Cultural Heritage Impact Assessment (CHIS) – Addendum

Robertson Martin Architects (RMA) was retained in May 2020 by Fotenn Planning Consultants to submit an update/ addendum to the *Cultural Heritage Impact Statement* (CHIS), prepared by RMA in May 2018, for the redevelopment of the Medical Arts Building Development (the site), at 180 Metcalfe Street, Ottawa. This addendum is written as part of an Application to the City of Ottawa for changes to the originally conceived and approved design (approved June 2019). It includes an increase in building height resulting in OPA, ZBA and Site Plan revision applications for 180 Metcalfe Street. This addendum will

SOUTH ELEVATION

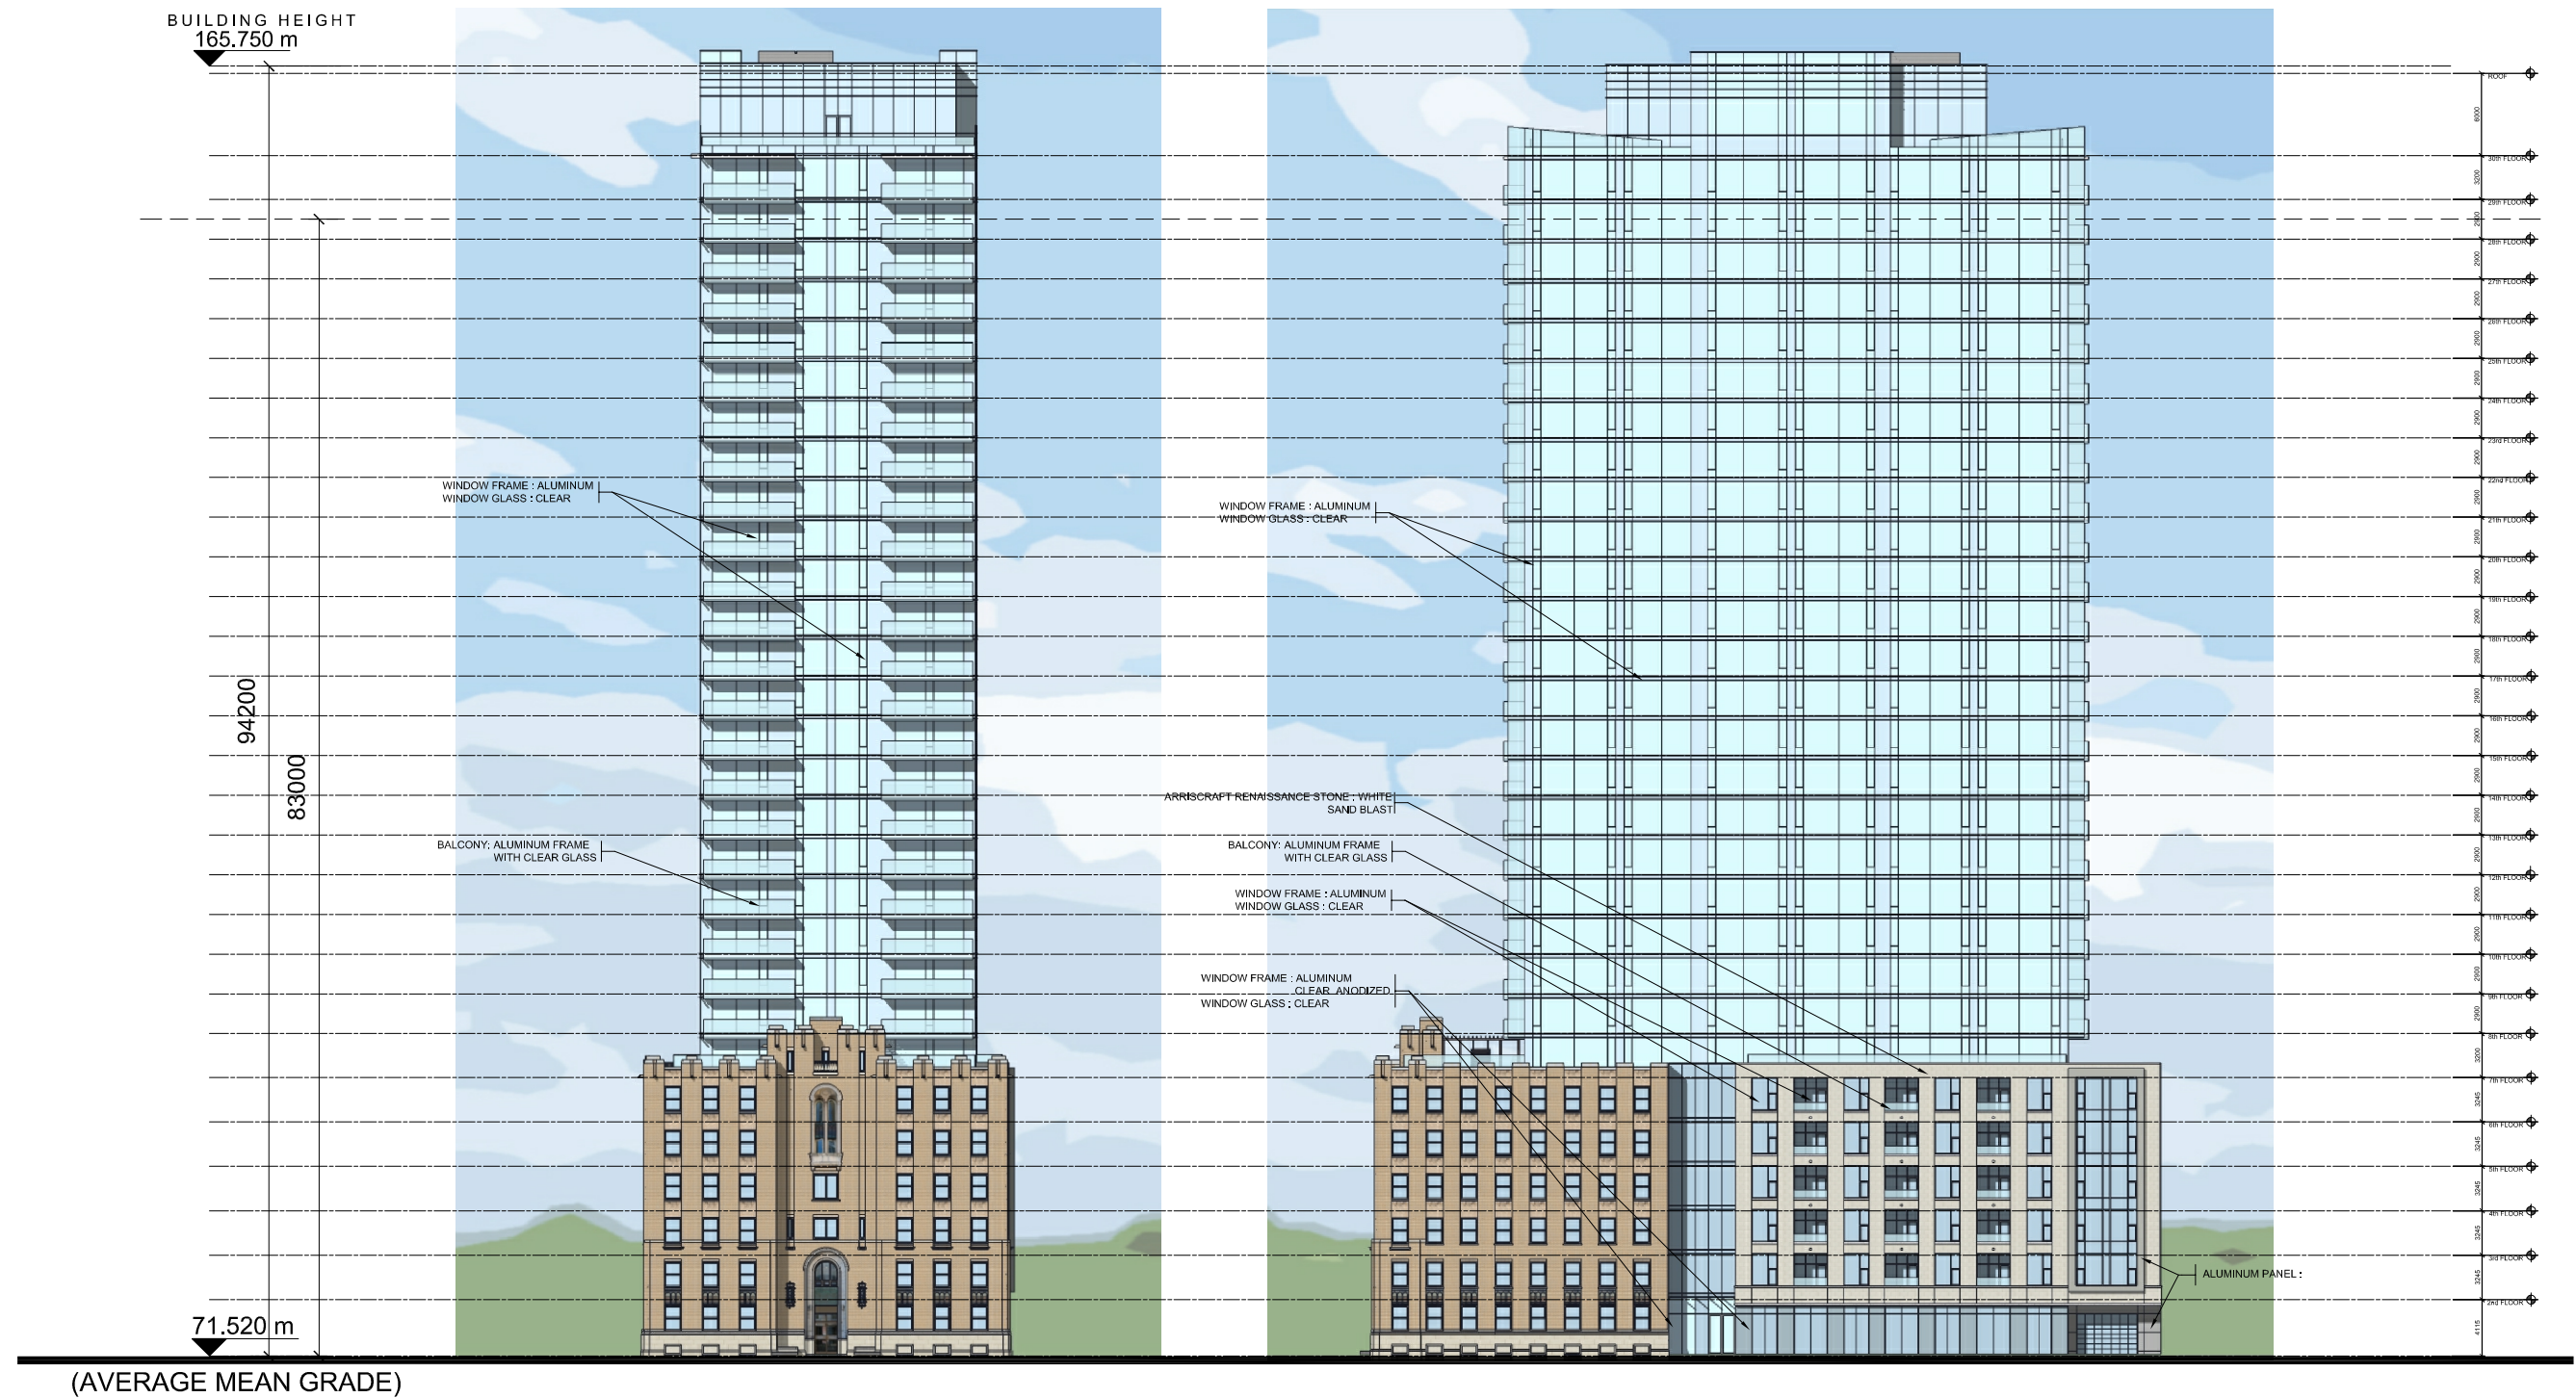
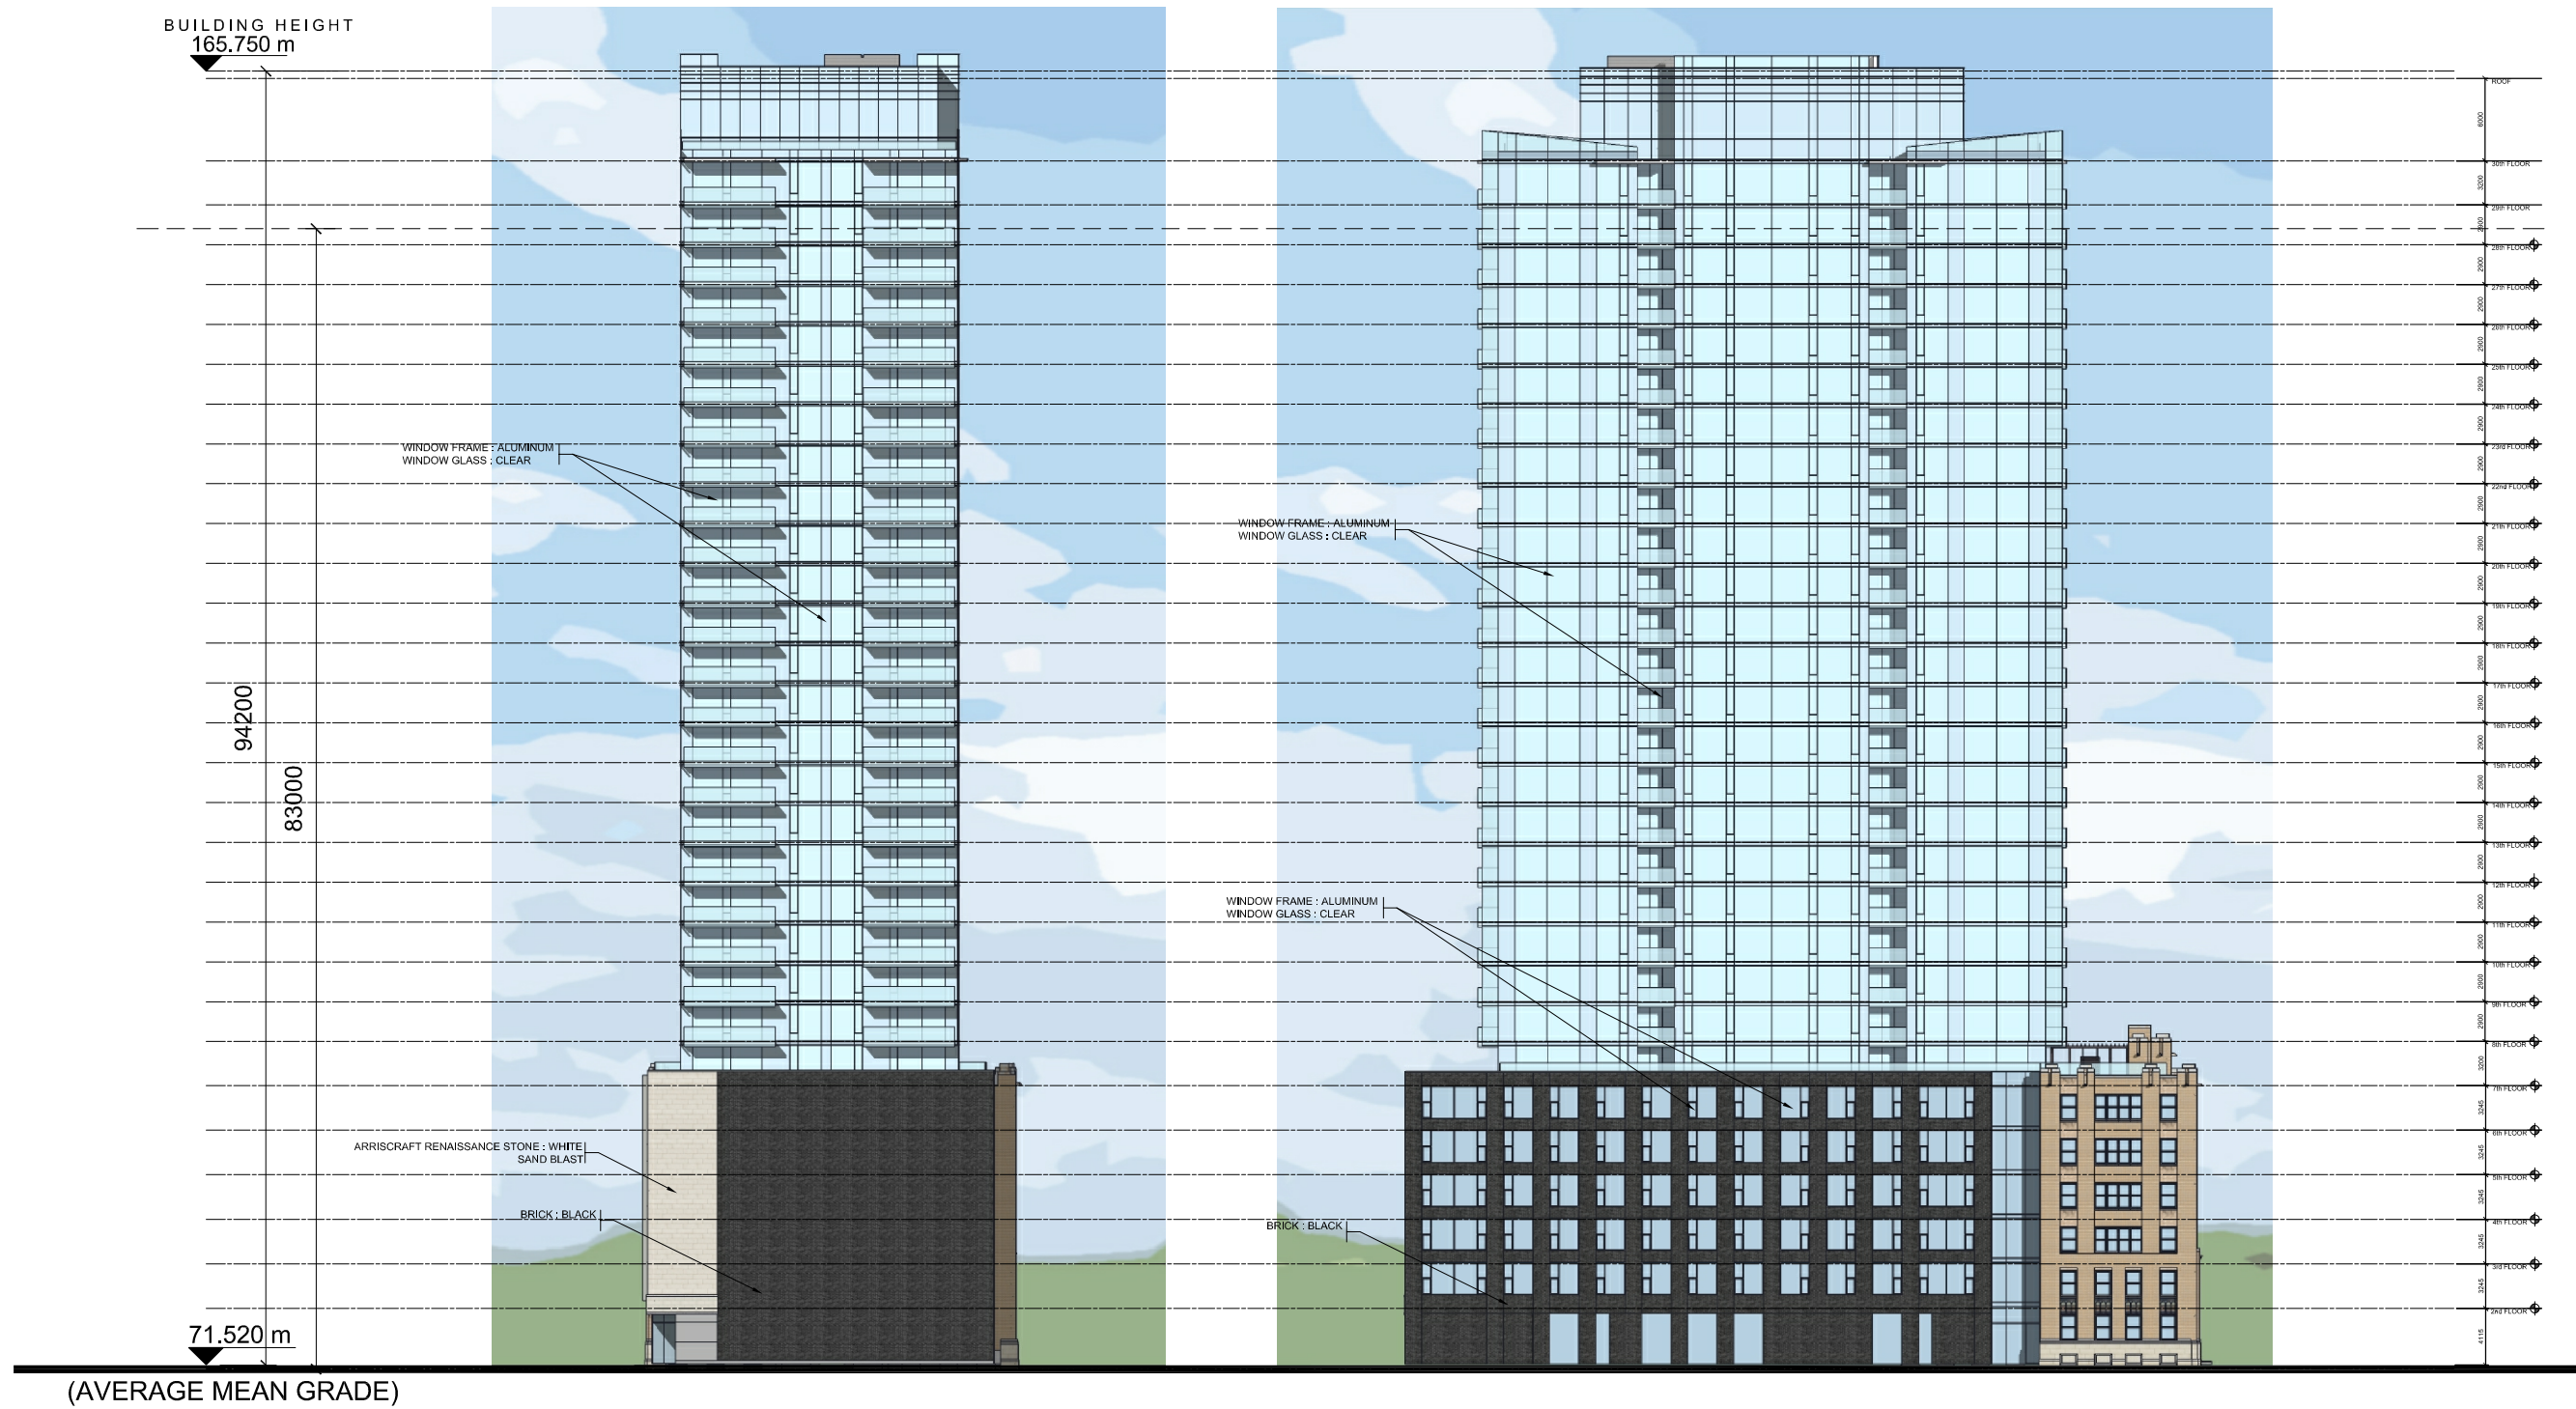
The recommended integration of a black “ribbon” element on the north façade should continue around the north-west corner on the west façade. On the west façade, minimal other changes are proposed to finishes from the original, and as such do not affect the previous impact assessment.

On the south façade, the use of black brick on all podium levels eliminates the distinction between the street level and the upper storeys as was evident in the original design. The design team should consider the use of the lighter brick at the ground floor to create a visual connection between the heritage building and the new façade. See *Fenestration and Massing* section above for further discussion on the street presence of the south elevation.

- The execution of the new construction should prioritize quality of materials and craft to compliment the quality of the heritage building;
- Consider use of black brick veneer between the first and second floor levels to highlight the continuation of the datum line created by the metal friezes on the heritage façade and to tie together the use of contrasting brick colours on all new podium elevations; and,
- The design team is encouraged to create a more intentional dialogue, between the podium and retained heritage facades, focusing on the proportions and rhythm of the fenestration of the heritage building, particularly on the south elevation.
